Your ref: SSD-11606719
File no: MC-20-00011

SSD-11606719 – Eastern Creek Recycling Ecology Park Throughput Increase

Blacktown Council's submission to SSD-11606719 – Eastern Creek Recycling Ecology Park Throughput Increase

Drawing Name:
Landscape Plan - 5

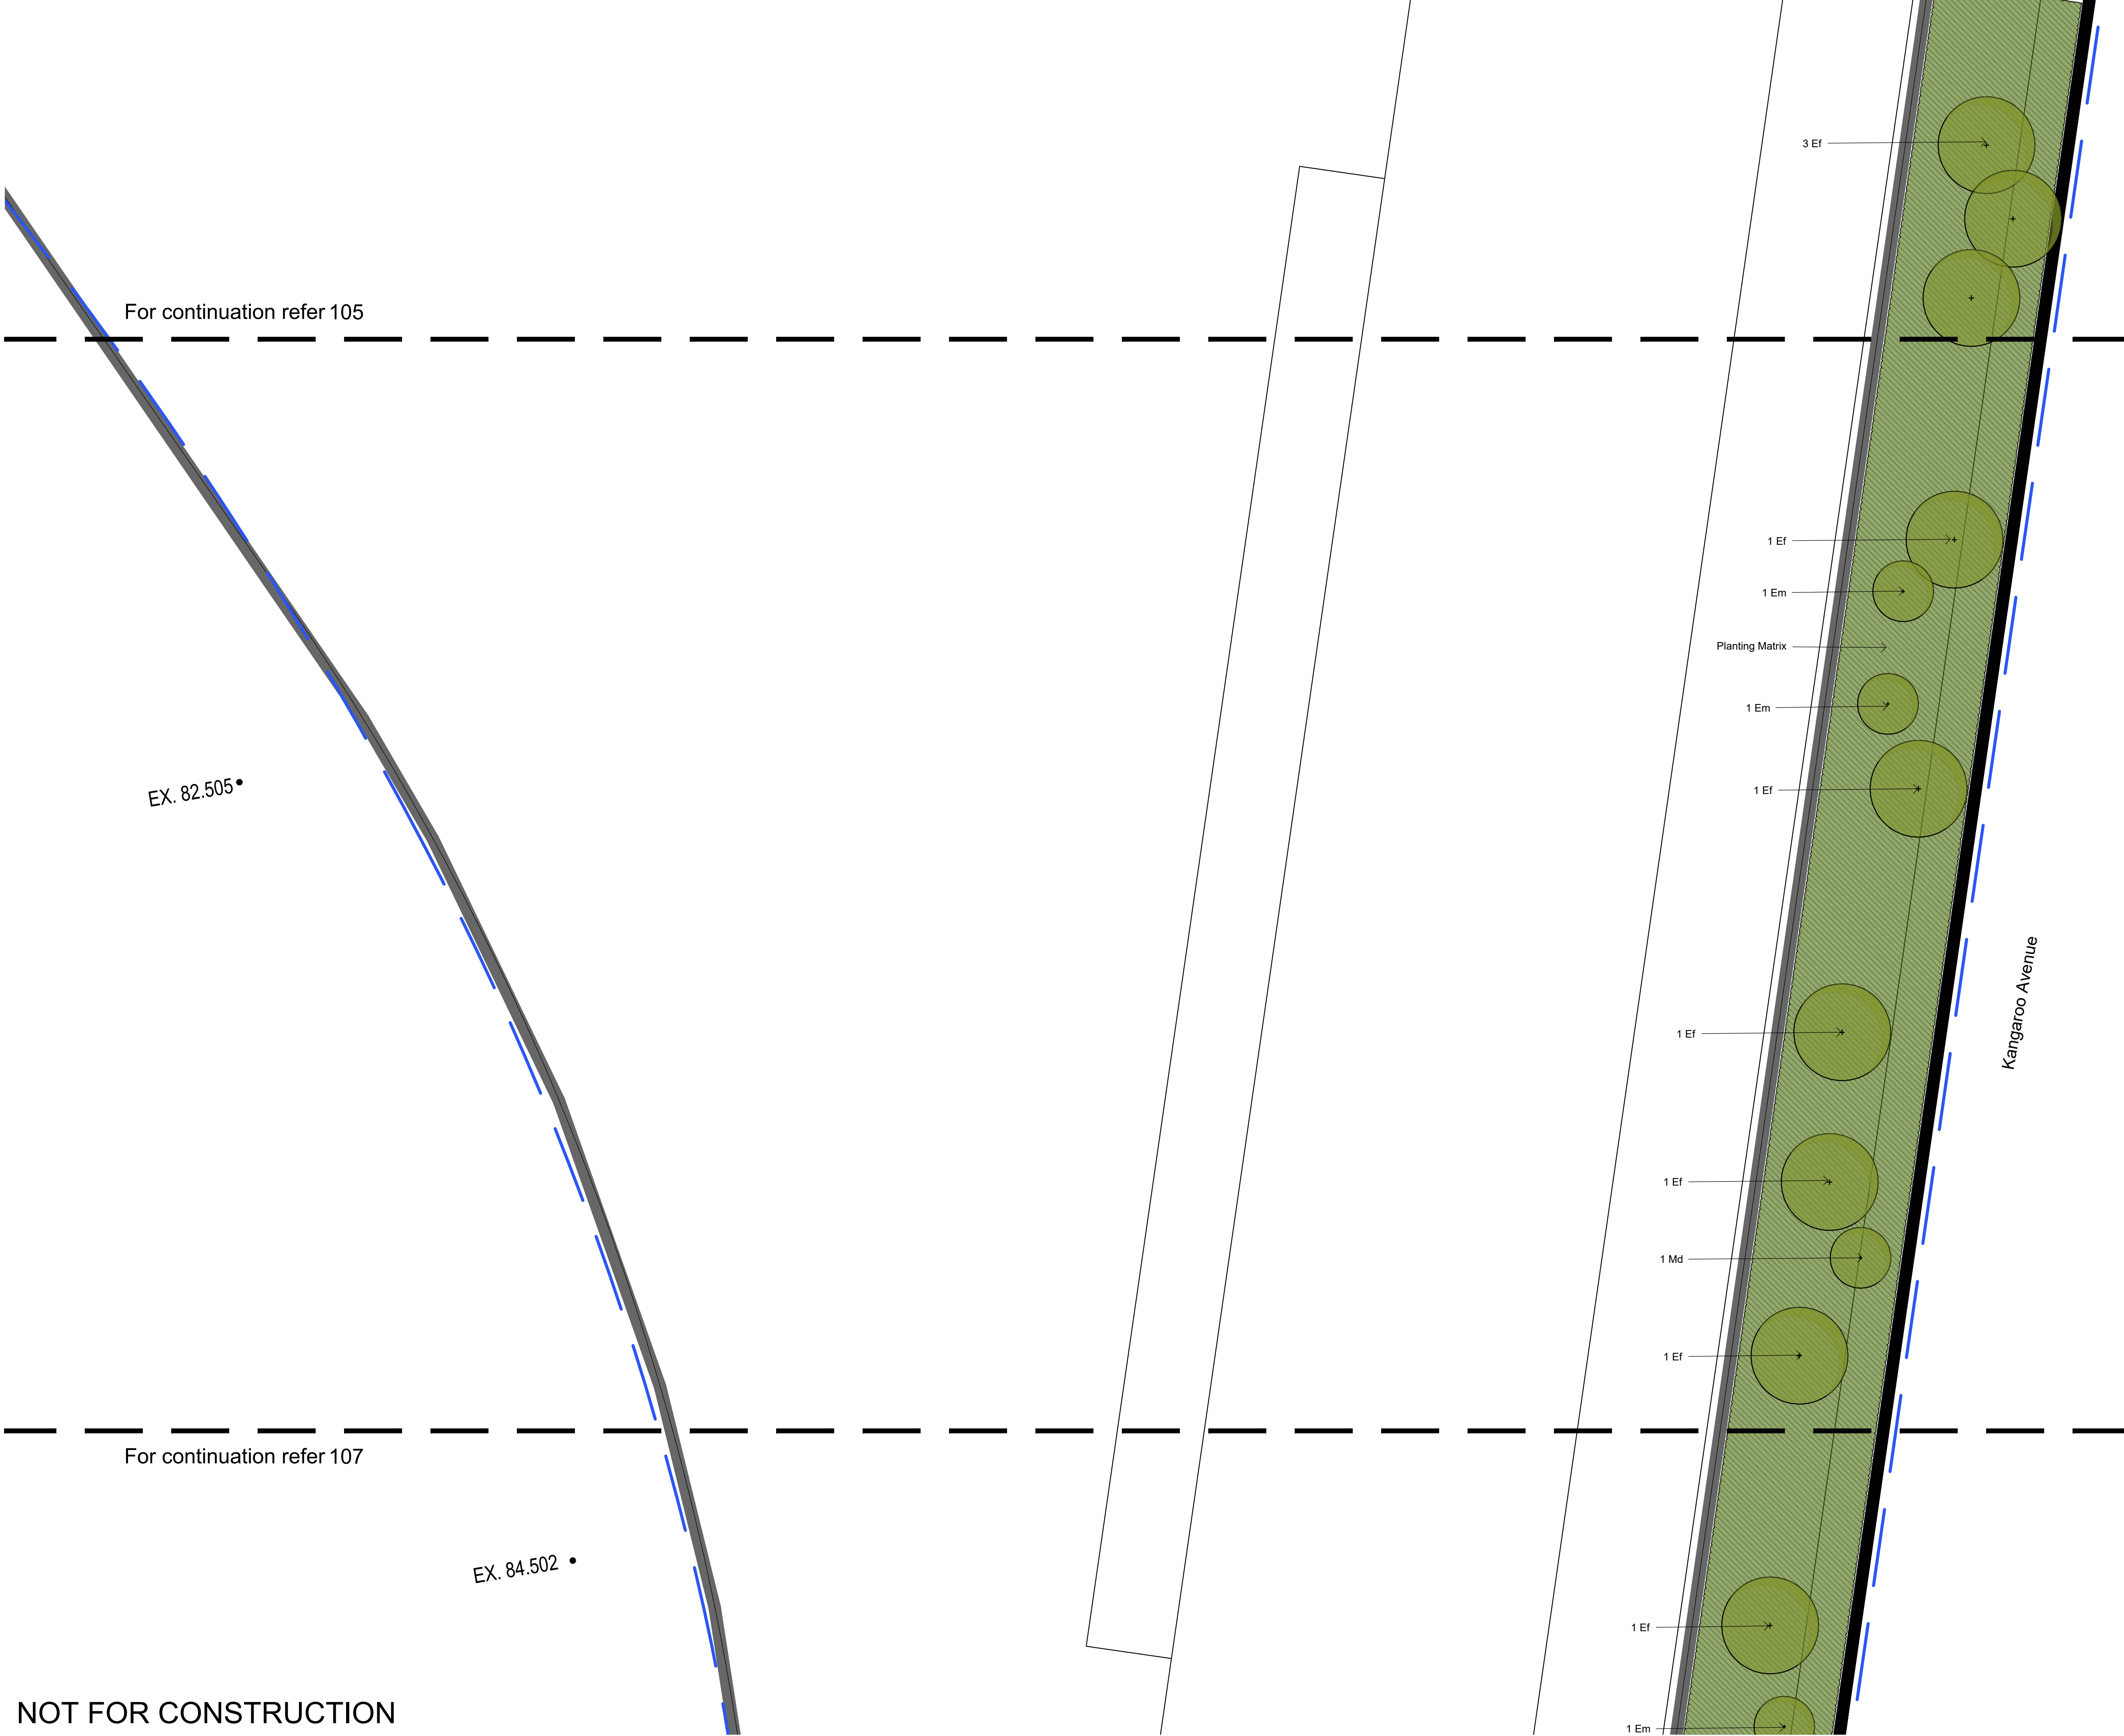
- h. The landscaping plan is to be updated, including landscaping to screen the car parking area from Honeycomb Drive.
- i. The landscaping and tree planting along the Kangaroo Avenue frontage of the site is to be extended in front of proposed Basin B to screen the retaining wall and basin from the street. An upwards climbing plant is also to be included for the retaining walls located adjacent to proposed Basin B.

- k. Proposed or existing landscaping directly to the south of the proposed maintenance and manufacturing workshop is also to be shown on the landscape plans to show how the bulk and the appearance of this building can be softened by landscaping.

- must include planting densities or numbers of plants proposed. As it is, the planting diagram looks too thin to meet the stated aims from the Environmental Impact Statement of “screen planting and perimeter fencing to be used along the eastern perimeter of the Proposal Site, between the Maintenance and Manufacturing Workshop and along Kangaroo Avenue to provide a natural visual barrier to soften proposed built elements”;
- must reconsider carpark species to include trees for shade in addition to groundcovers and instead of broad, spiny shrubs like *Bursaria spinosa* or thin low trees like *Acacia decurrens*.
- must propose planting trees at a higher pot size than 45L (minimum 200 L to ensure establishment success).

Project	EASTERN CREEK RECYCLING ECOLOGY PARK THROUGHPUT INCREASE
Title	ROADWORKS AND STORMWATER DRAINAGE PLAN SHEET 4

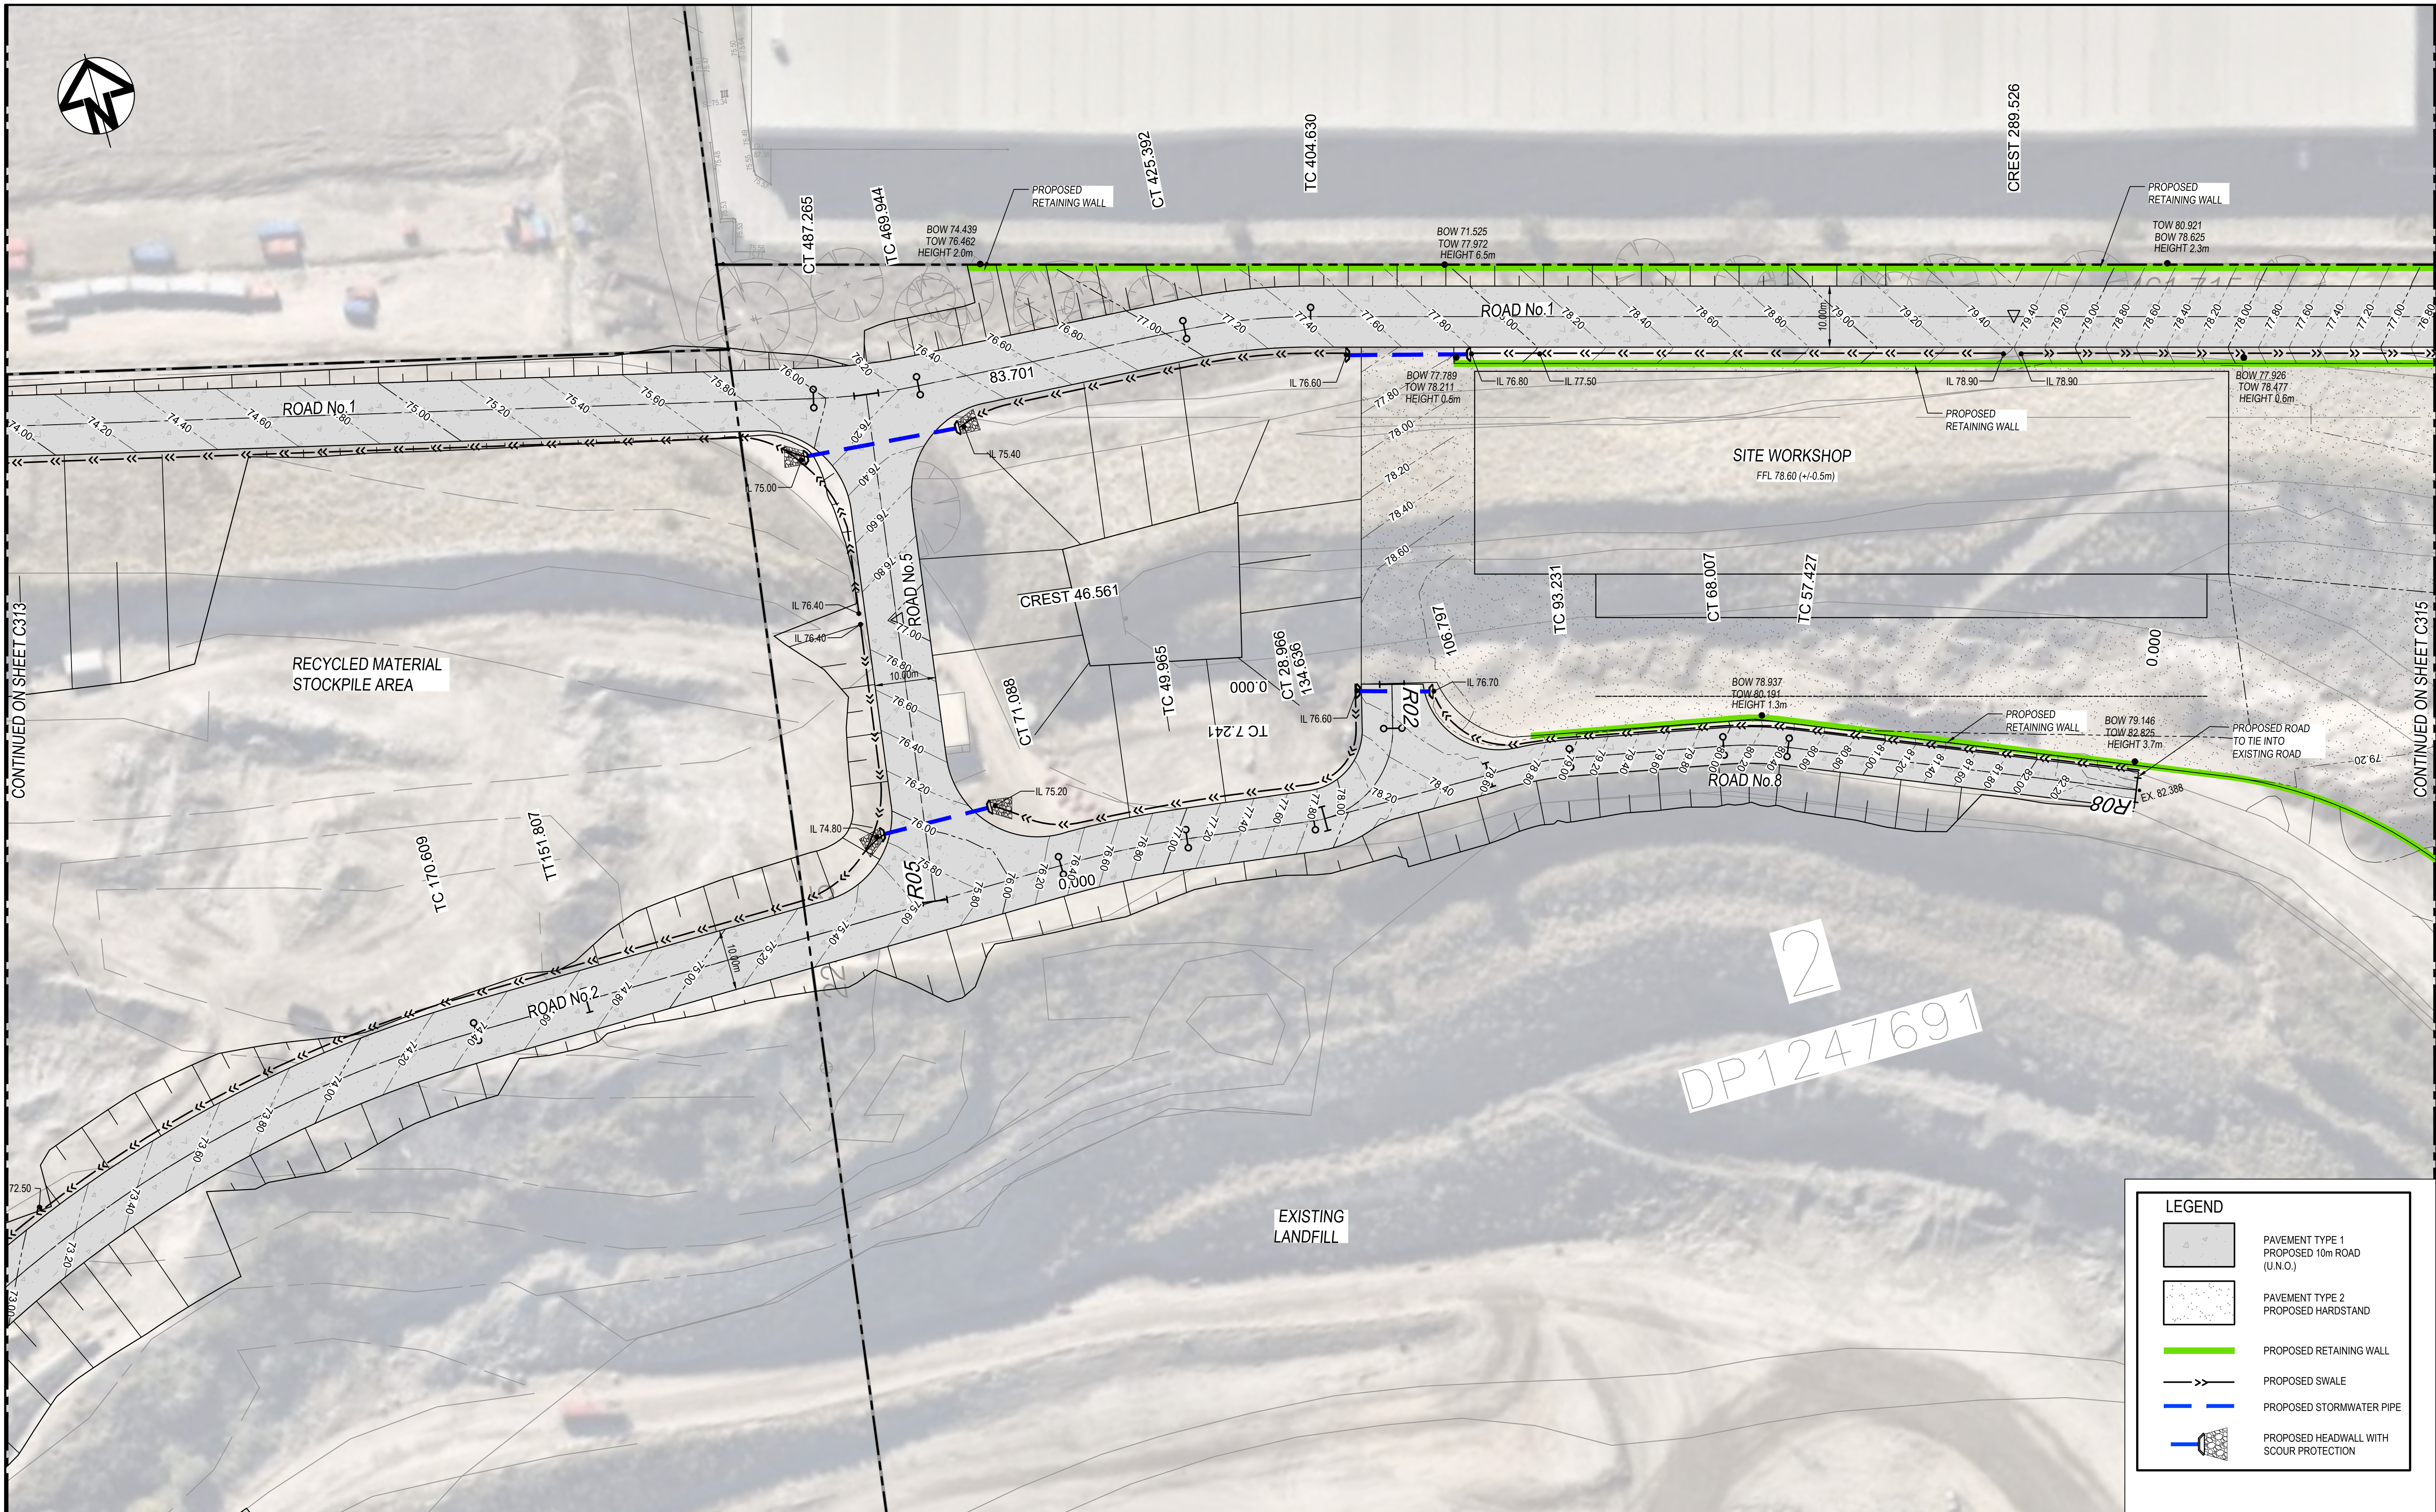
4. Provide amended drainage plans from at&I Project No. 19-692 to address the following:
 - a. There is insufficient information shown on drawing C313(F) to understand how Basin K will operate. It is understood to be only a detention basin. On a dedicated separate plan provide detailed plans and sections through Basin K. Provide details of the control pits and weirs and pipe(s) out. Provide a vehicular access ramp down to the base of the basin.
